DOC23/57412-9

6 March 2023

**Planning Referral – Advice Request – Environmental Impact Statement
Hunter Valley Operations North Open Cut Coal Continuation Project (SSD-11826681)
Hunter Valley Operations South Open Cut Coal Continuation Project (SSD-11826621)**

The EPA has reviewed the EIS titled '*Hunter Valley Operations Continuation Project Environmental Impact Statement*' prepared by EMM consultants dated December 2022 and the related Appendices including Appendix H of the EIS - '*Air Quality and Greenhouse Gas Assessment*', prepared by Jacobs Pty Ltd, dated 9 November 2022 (the AQIA).

Figure 1 Potentially highest impacted receptors based on modelled 24-hour average PM₁₀ concentrations

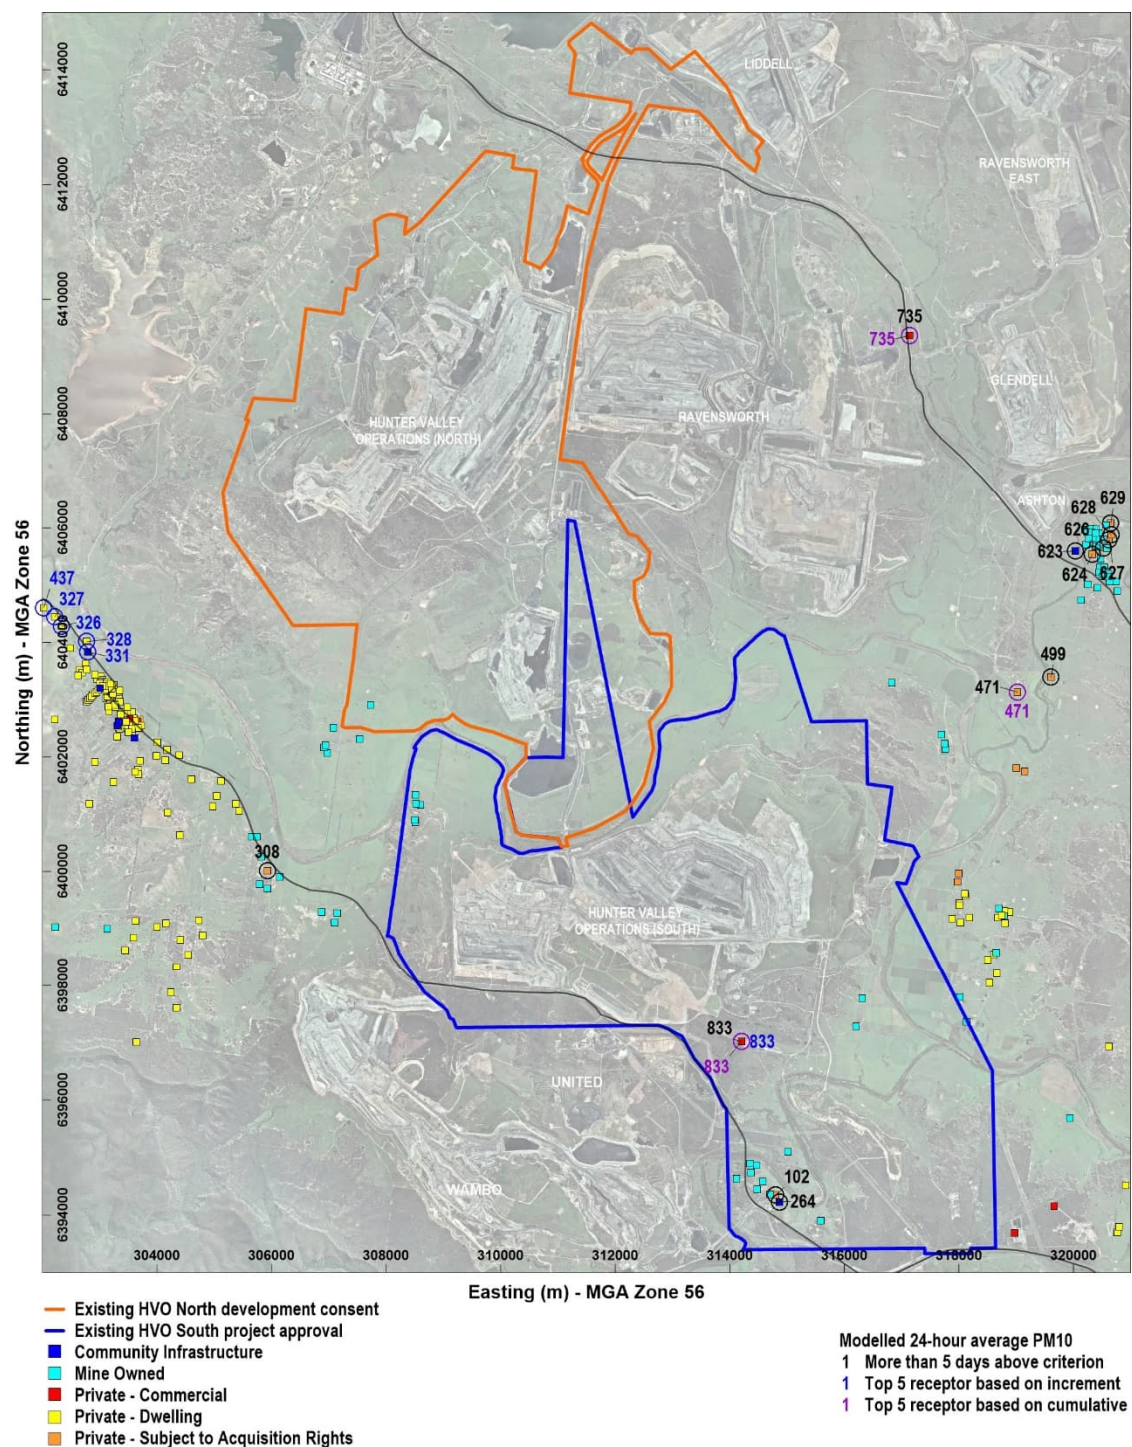
1. Provide revised dispersion modelling scenarios to include the actual implementation of the proposed reactive mitigation measures to demonstrate that their implementation will reduce the risk of additional exceedances occurring.

- a. Detailed discussion to demonstrate that the dispersion modelling has allowed for 'reaction time/delay' to implement the corresponding reactive measures.

- b. Specific 'triggers' (e.g., meteorological conditions, concentrations) and specific actions to be used to inform the implementation of reactive measures.

- d. A summary of the number of hours/days the reactive measures were included in the modelling.
- e. Presenting a timeseries graph of cumulative impacts showing the effect of implementing the reactive control measures at a minimum of two of the most impacted receptors (i.e., receptors with the largest predicted increments). This must include but is not necessarily limited to:

- Predicted concentrations with and without the implementation of the proposed reactive controls.
 - The levels used to trigger the implementation of the proposed reactive controls.

Figure 3 Relationships between PM_{2.5} and PM₁₀ concentrations from data collected at Kelly in 2023

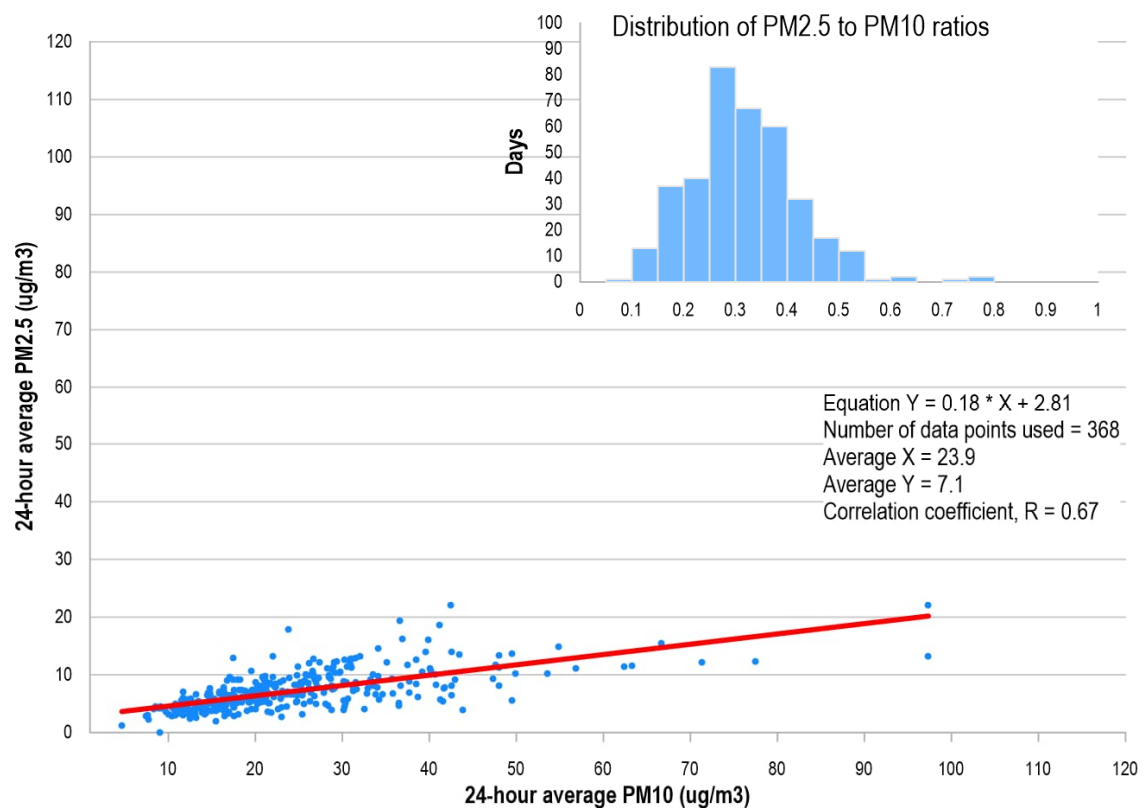
5. Provide additional information about the assumptions made to derive the PM_{2.5} background levels used in the assessment.

The AQIA states that “the derived PM_{2.5} background levels follow the same profile as the derived PM₁₀ background but with an annual average that matched the available and more recently (2020) measured PM_{2.5} concentrations near the project at the Kelly monitoring location”. However, it is still unclear what this actually means and how the daily PM_{2.5} concentrations were calculated or compared against recent data.
